Sikh Grammar School Rouse Hill (SSD-9472)
Request for Additional Information

I refer to Response to Submission (RTS) and Supplementary RTS for the Sikh Grammar School Rouse Hill (SSD-9472). After careful consideration, the Department is requesting that you provide the following additional information:

PMDL
ARCHITECTURE
INTERIORS
MASTERPLANNING

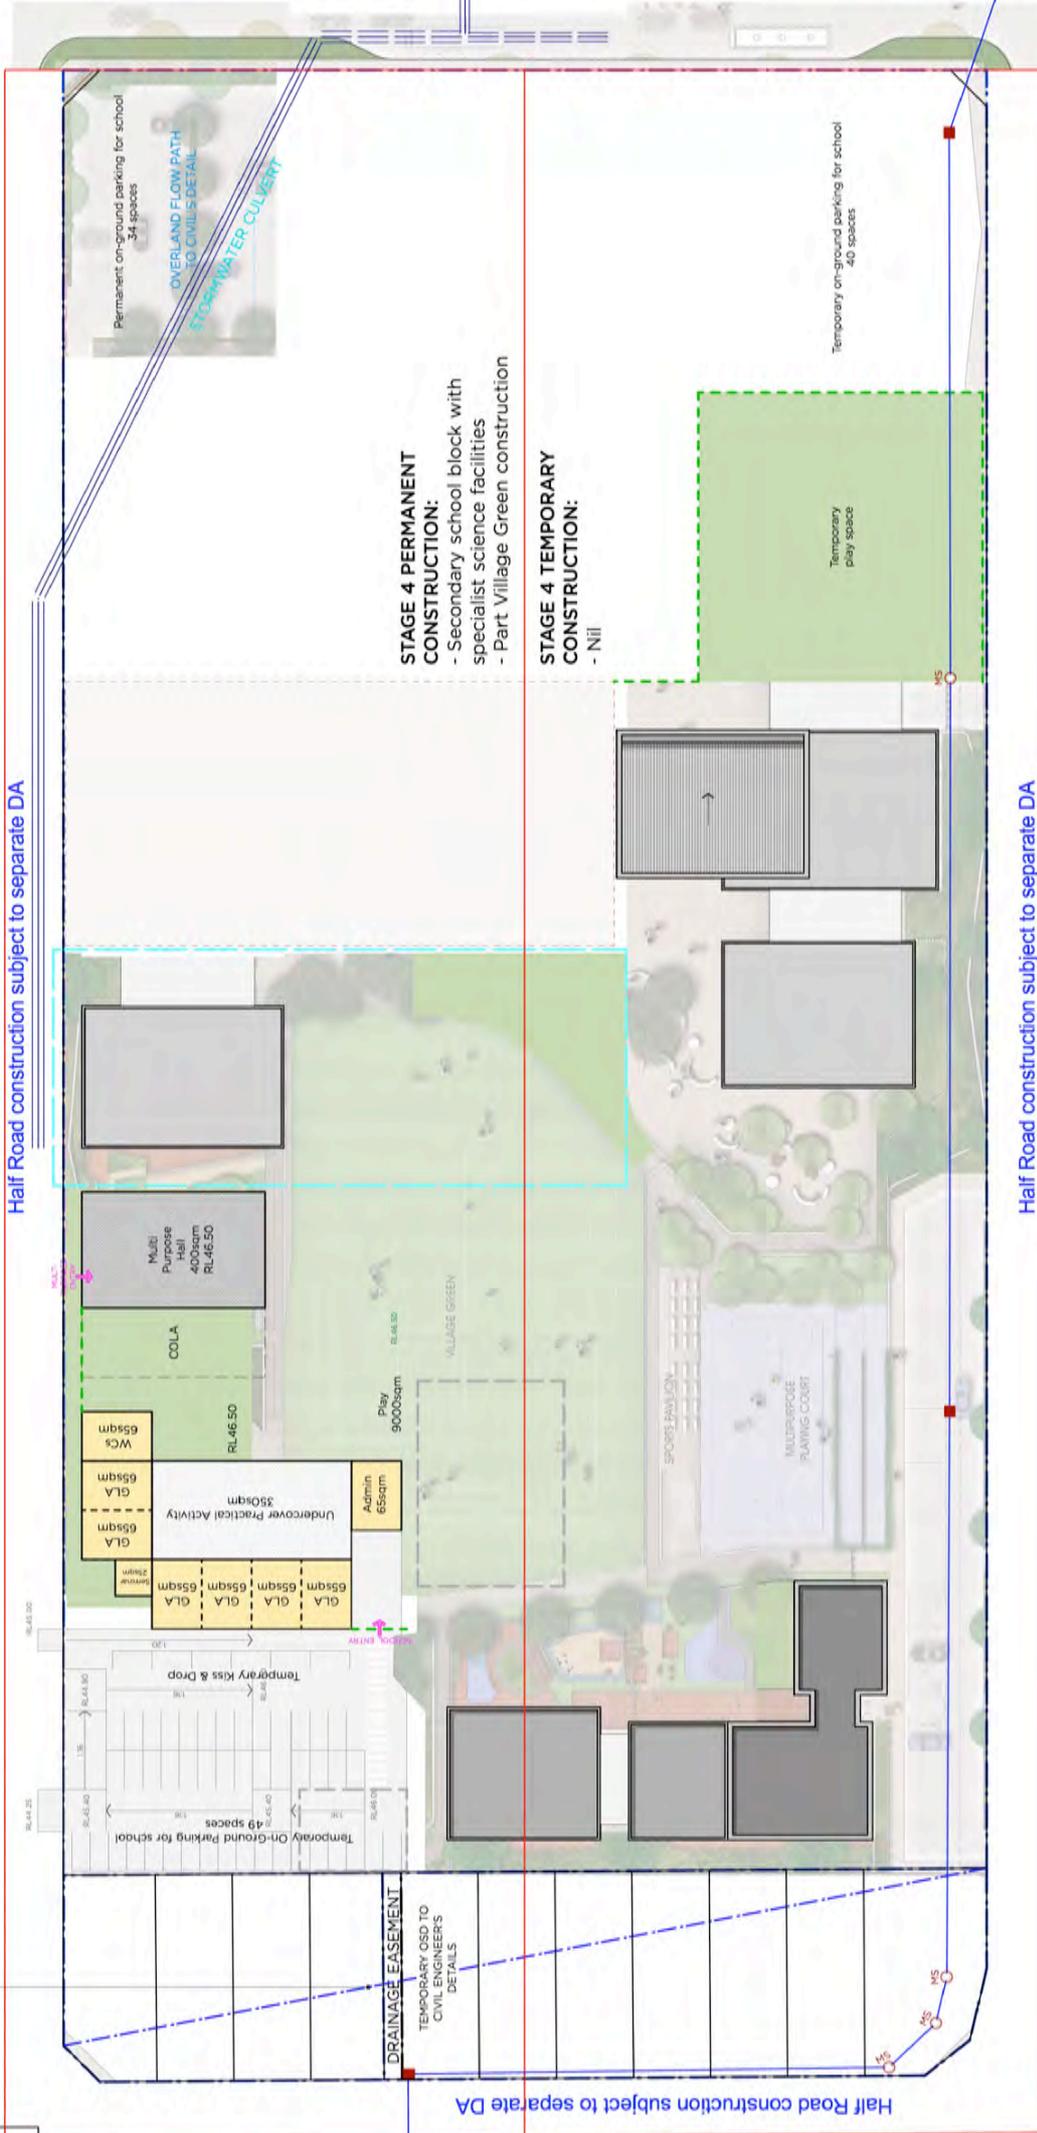
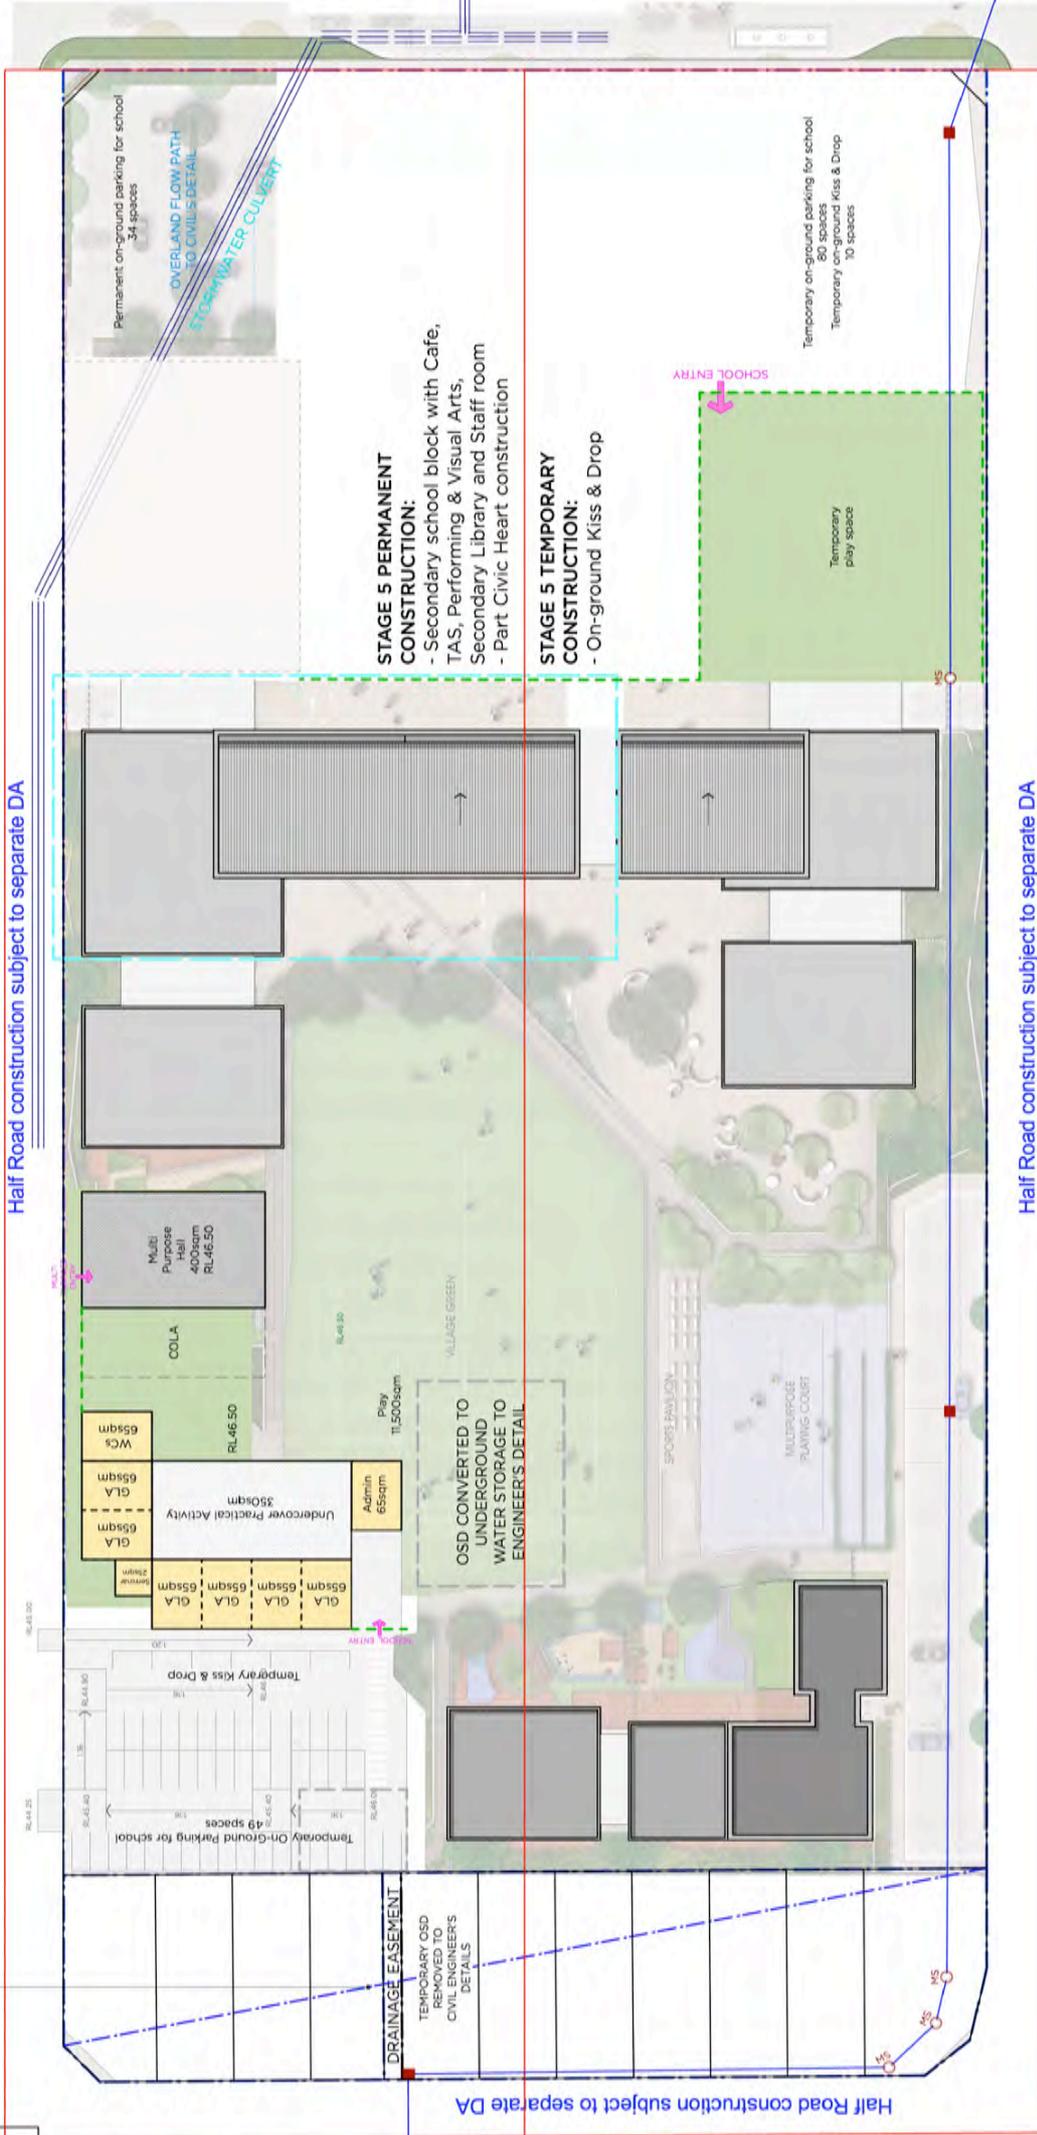
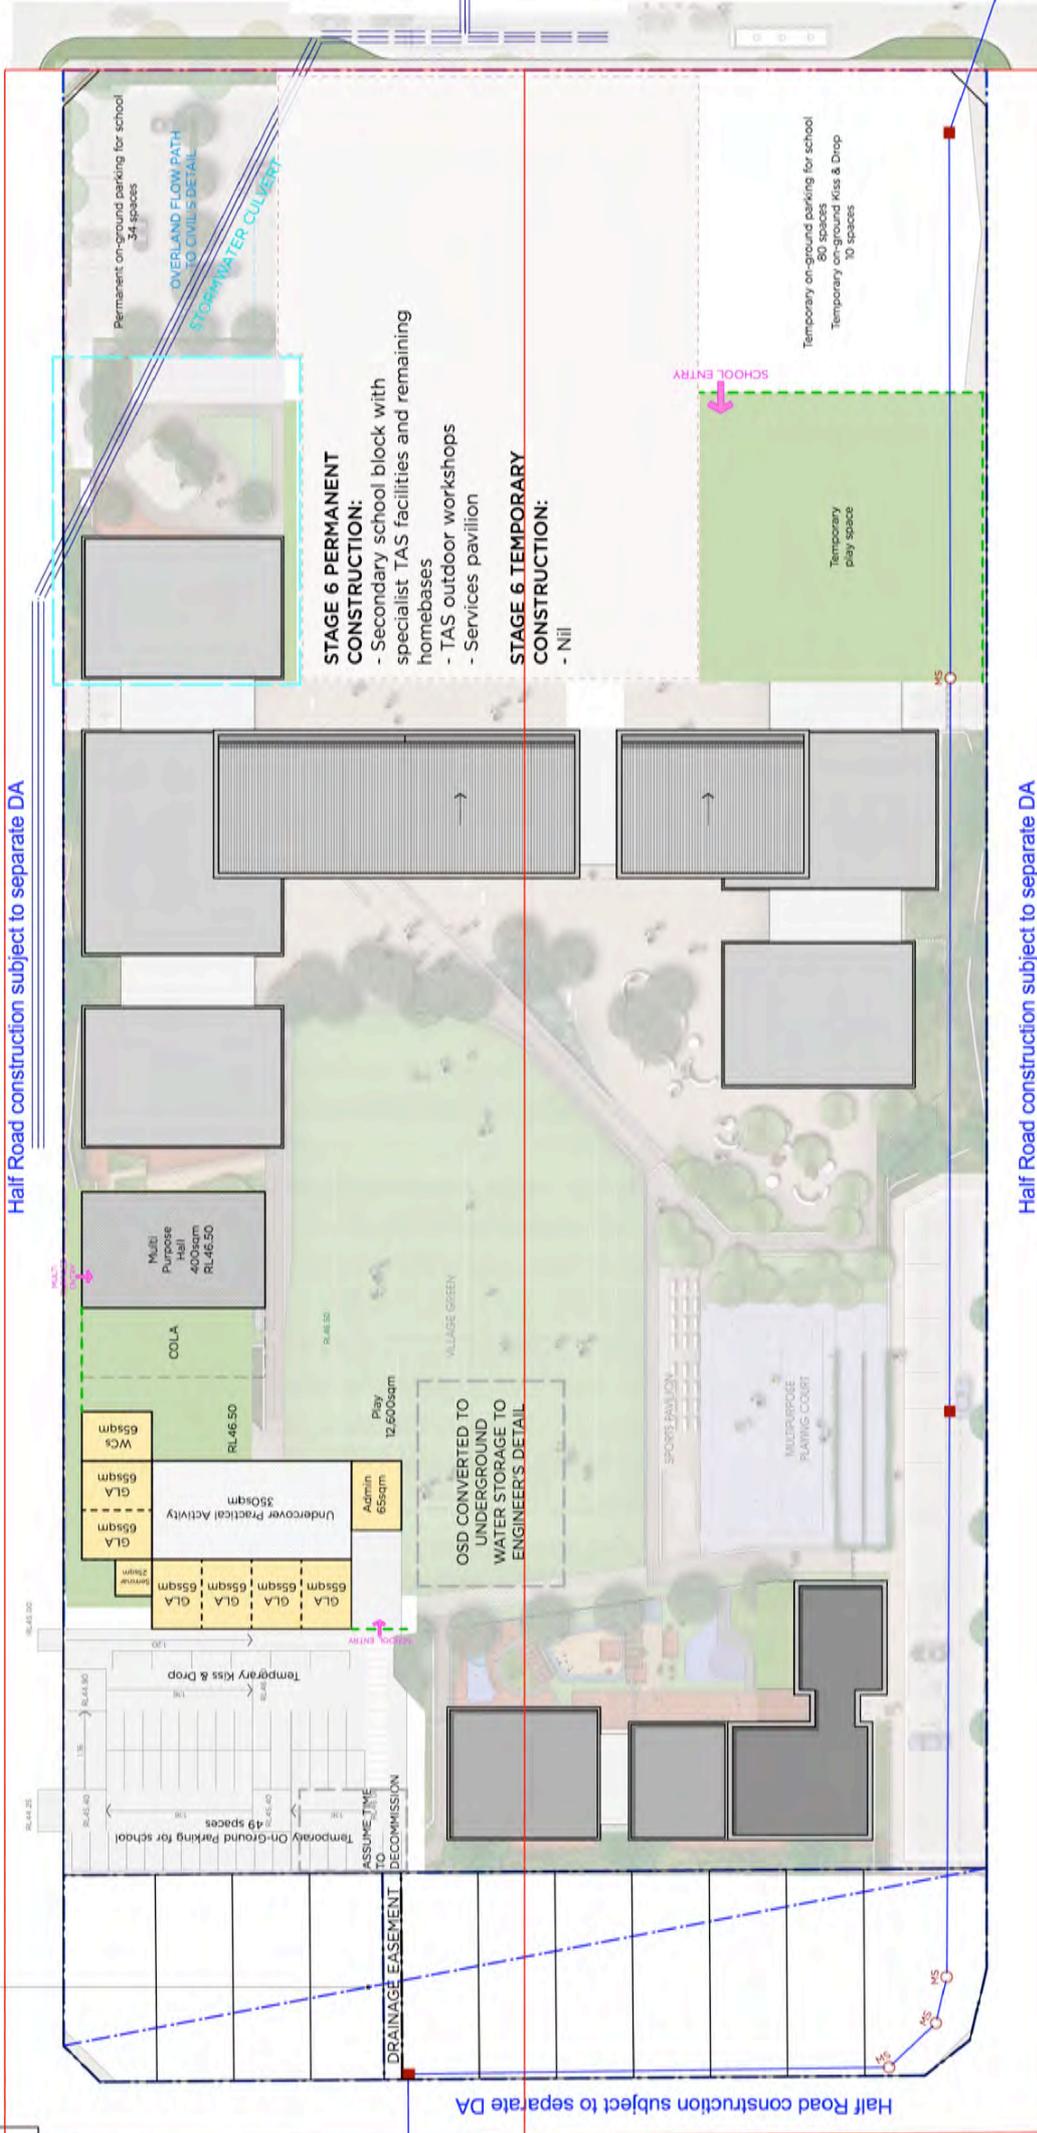
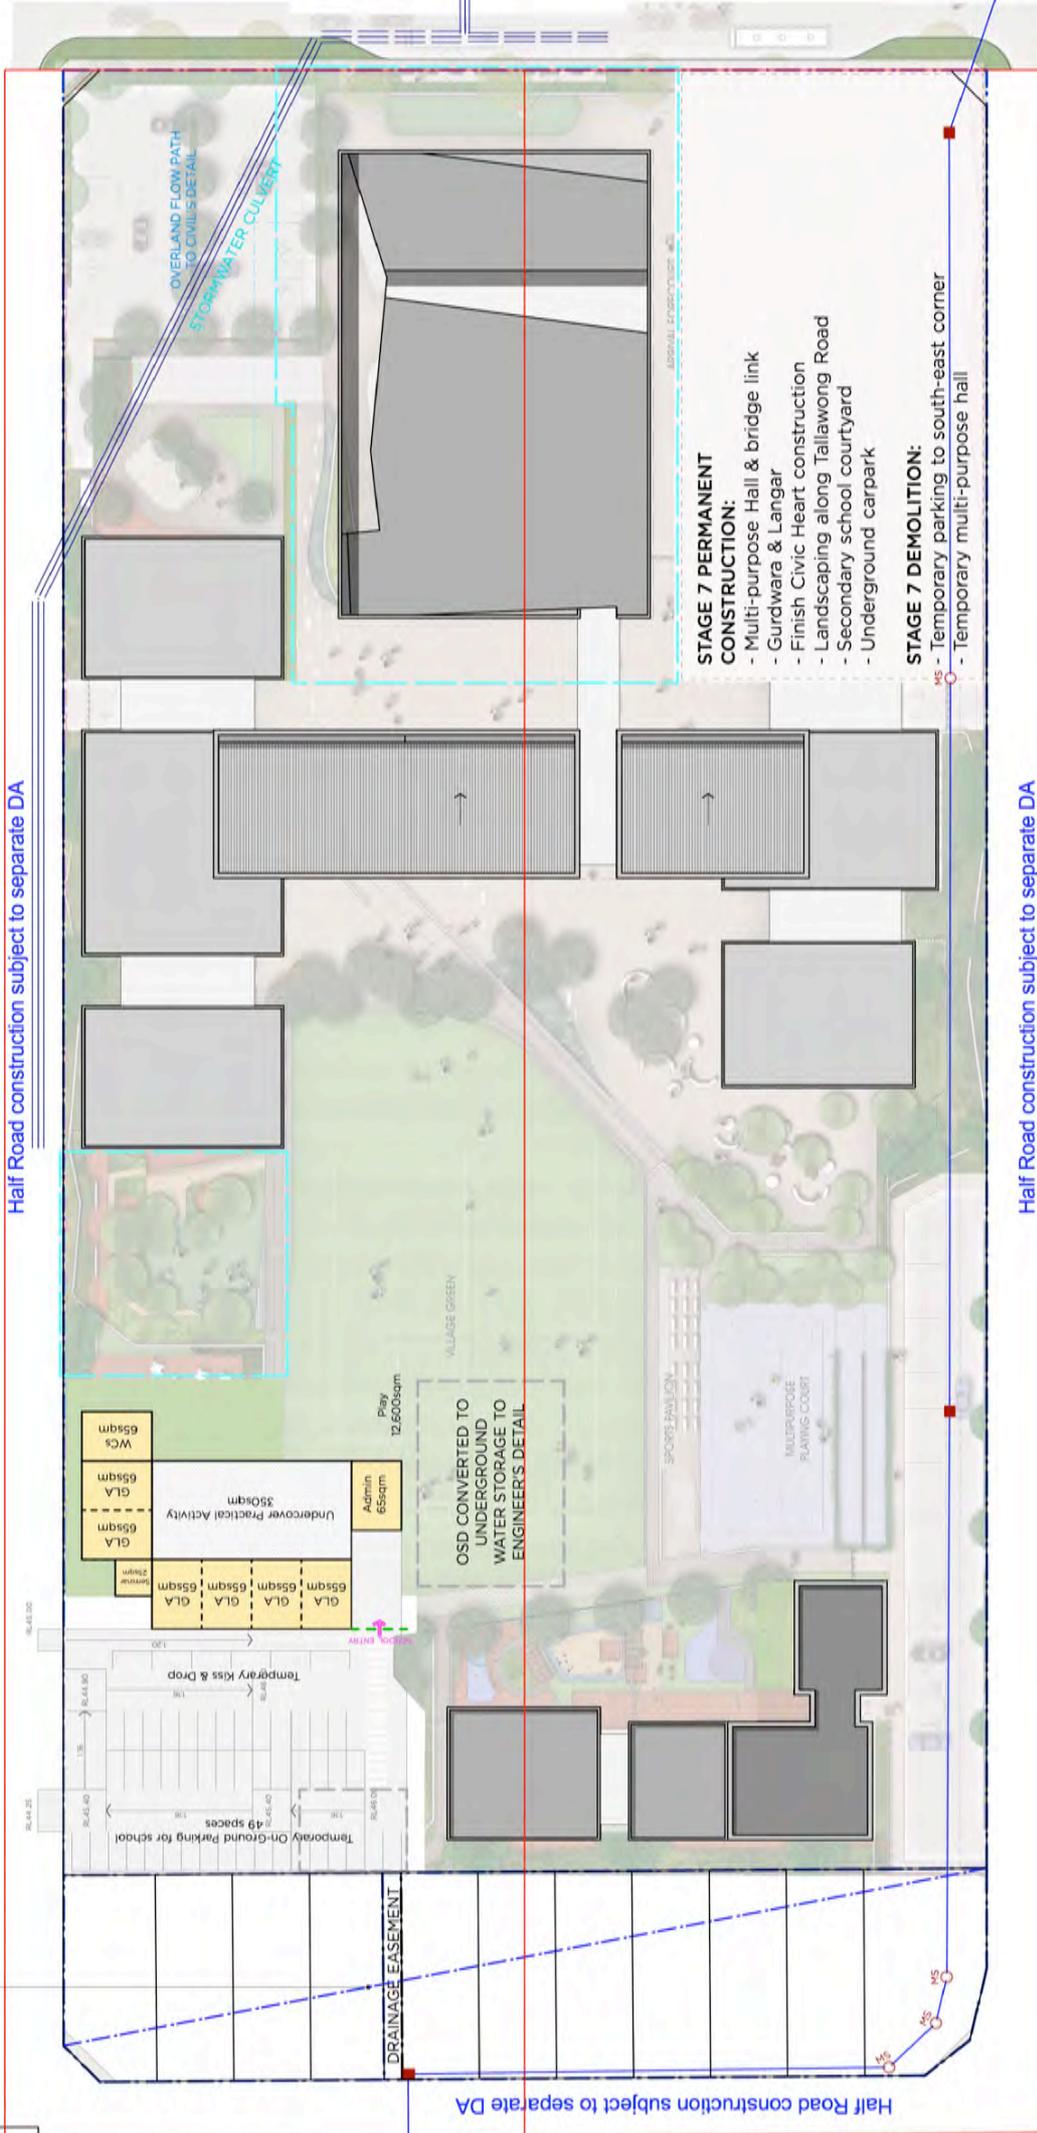
It is noted that throughout all the submitted documents (EIS report, RTS report and supplementary RTS) the construction timeframe is stated as 10 years. However, the staging plans in the Architectural Design Report (pages 59- 69 in Appendix 4 of the RTS) reflects 24-year timeframe. These staging plans are to be revised to reflect a 10-year construction timeframe so it's consistent with the submitted documents.
